from  
**Southern  
Water**

Your ref  
BE/121/21/RES

**Proposal:** Approval of reserved matters following BE/135/18/PL for appearance, landscaping and layout of Unit 3. This application may affect the character & appearance of the Shripney Conservation Area & is in CIL Zone 2 (Zero Rated) as other development.

**Site:** BE/121/21/RES: - Unit 3 Land at Salt Box West of Shripney Road, Bognor Regis, PO22 9NW.

HYDROCK PROJECT NO. C-13319-C	SCALE @ A1 1:250
STATUS DESCRIPTION TENDER	STATUS D2
DRAWING NO. (PROJECT CODE-ORIGINATOR-ZONE-LEVEL-TYPE-ROLE-NUMBER) SAL-HYD-PH3-ZZ-DR-C-7010	REVISION P04

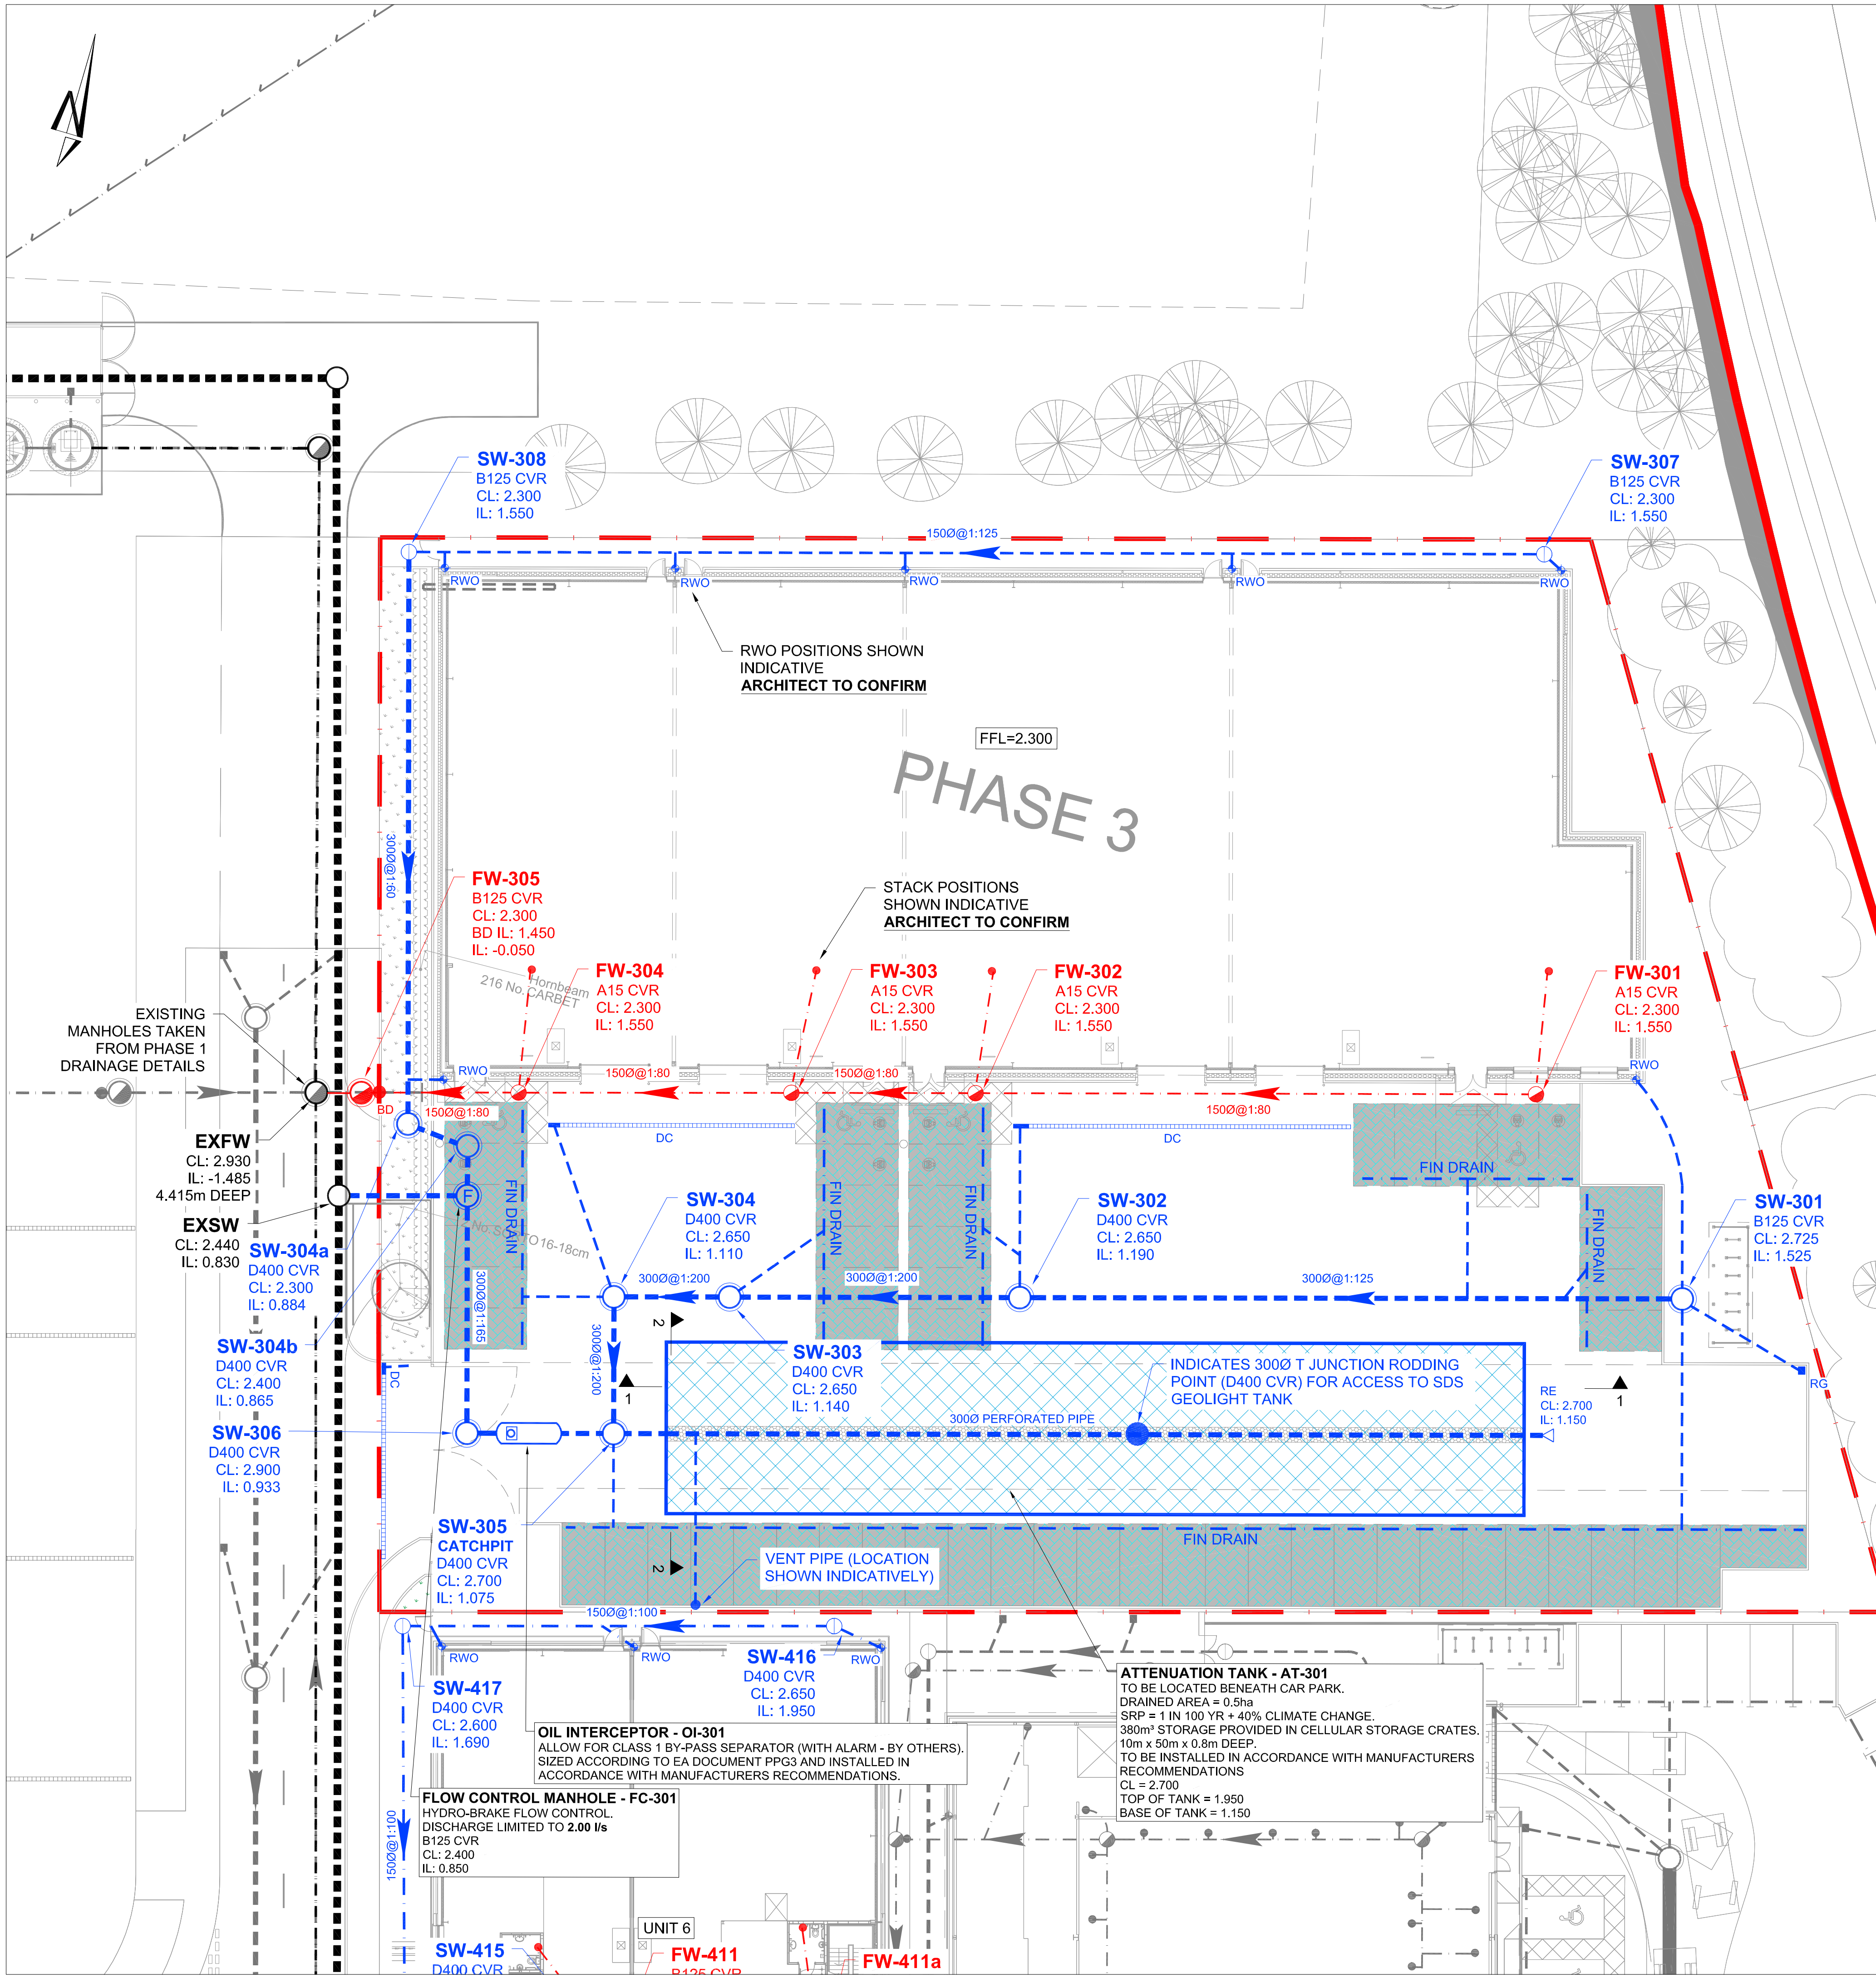
The submitted drainage layout (Drawing number: SA-HYD-PH3-ZZ-DR-C-7010- P04) is satisfactory to Southern Water.

No discharge of foul sewerage from the site shall be discharged into the public system until offsite drainage works to provide sufficient capacity within foul network to cope with additional sewerage flows are complete. Southern Water is currently in process of designing and planning delivery of offsite sewerage network reinforcements.
